KIRKLEES METROPOLITAN COUNCIL INVESTMENT & REGENERATION SERVICE

DELEGATED DECISION TO DETERMINE PLANNING APPLICATIONS

Reference No:	2026/62/90664/W
Site Address:	65B, Westgate, Almondbury, Huddersfield, HD5 8XF
Description:	Alterations to convert garage to living accommodation to include new rooflight and window and amended window size (Listed Building within a Conservation Area)
Recommending Officer:	Joanna Rednall

DECISION – CONDITIONAL FULL PERMISSION

Title
Window and door details.

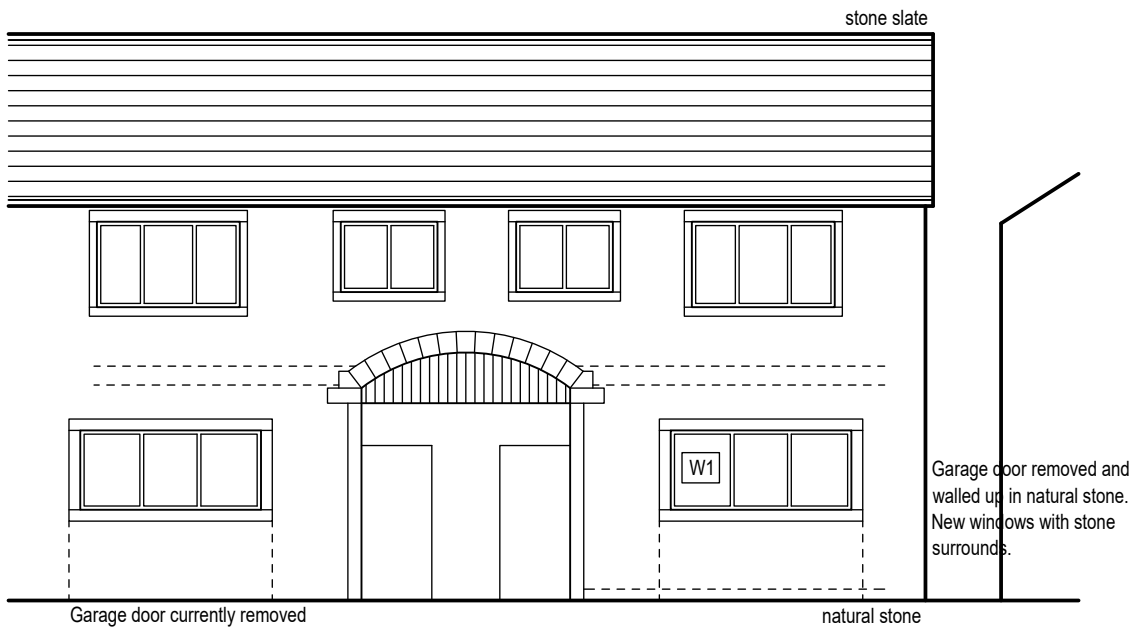
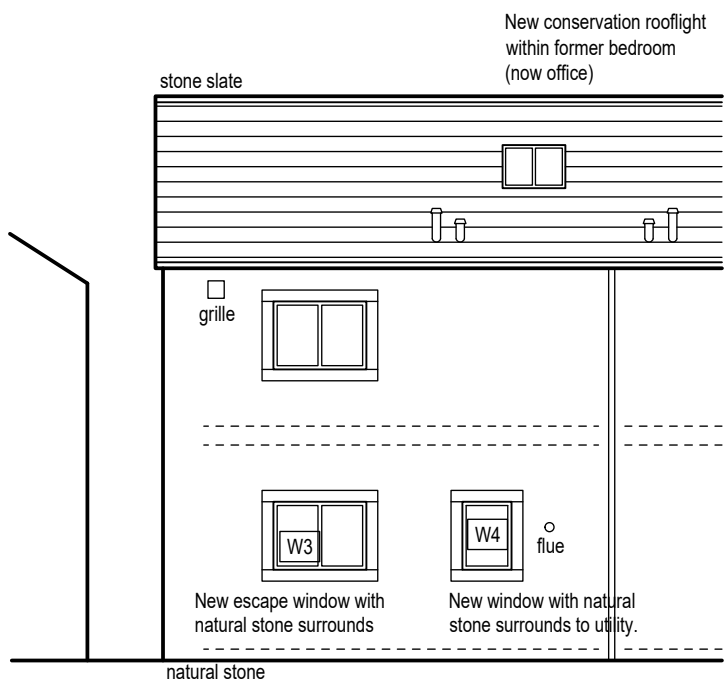
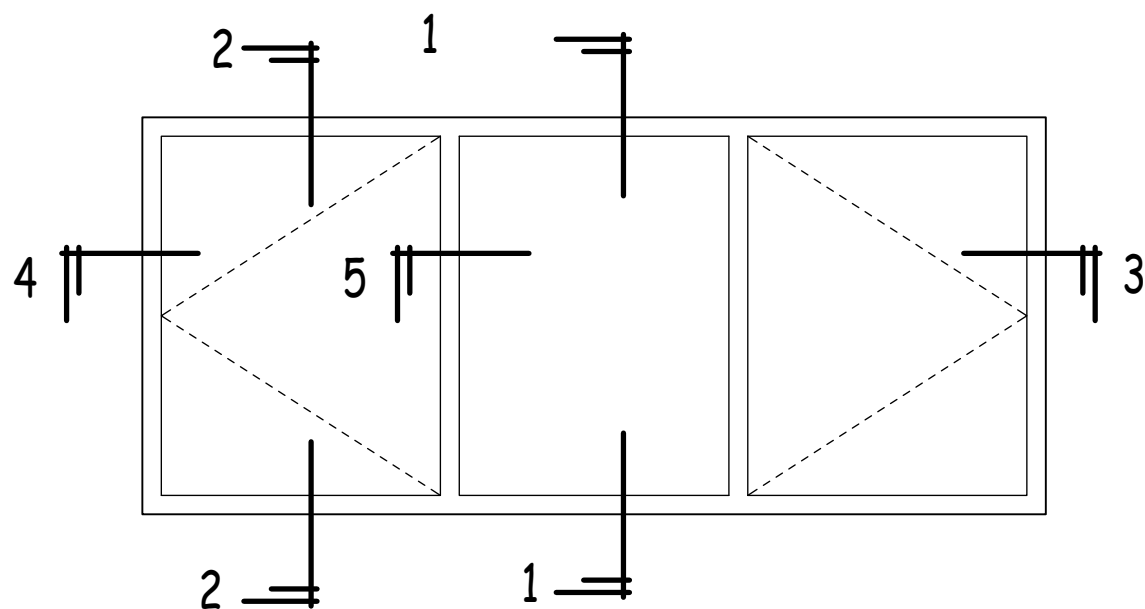
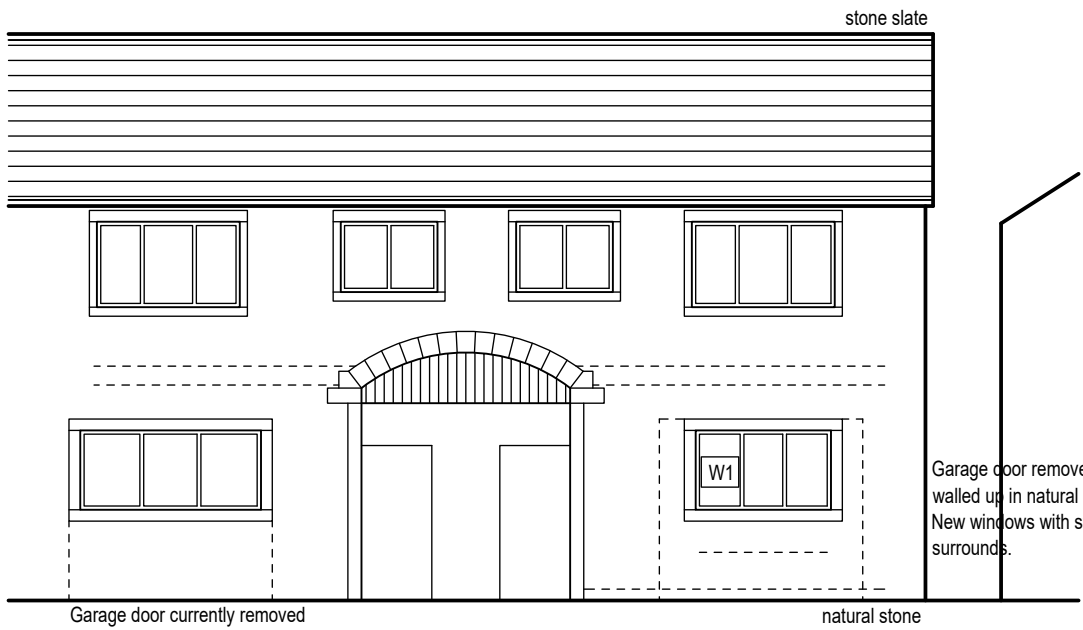
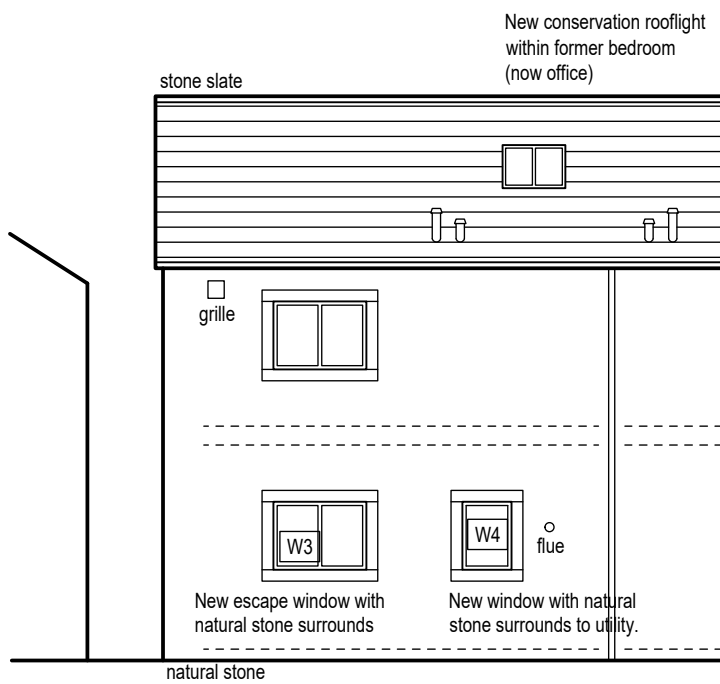
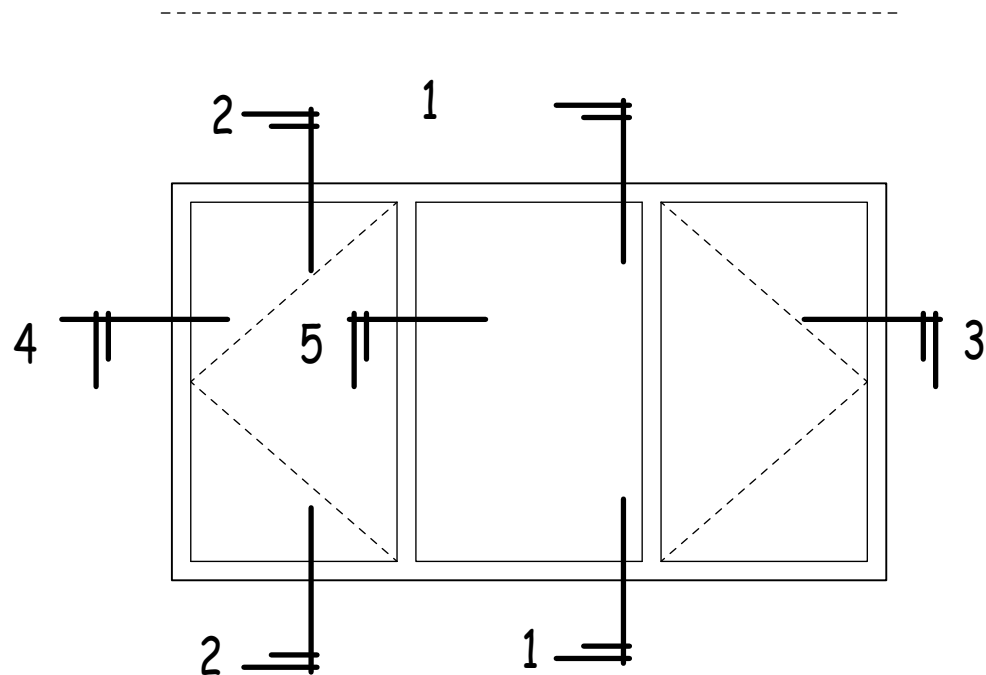
The case officer sought amendments to reduce the size of the ground floor windows to align with existing first floor openings. Amended plans were submitted and the application has been progressed to determination on the basis of these.

KC Conservation and Design were consulted on the proposal and initially raised concerns regarding the width of the proposed ground-floor windows, and officers advised that these openings should be reduced to better reflect the proportions of existing windows. Amended plans have since been

submitted incorporating these changes, and the revised design now aligns more closely with the established character of the building. Given these amendments and considering the small-scale nature of the works, it is considered that the proposal would not result in harm to the significance of the listed building, subject to appropriate condition requiring use of matching materials and that the development is undertaken in accordance with the submitted plans.
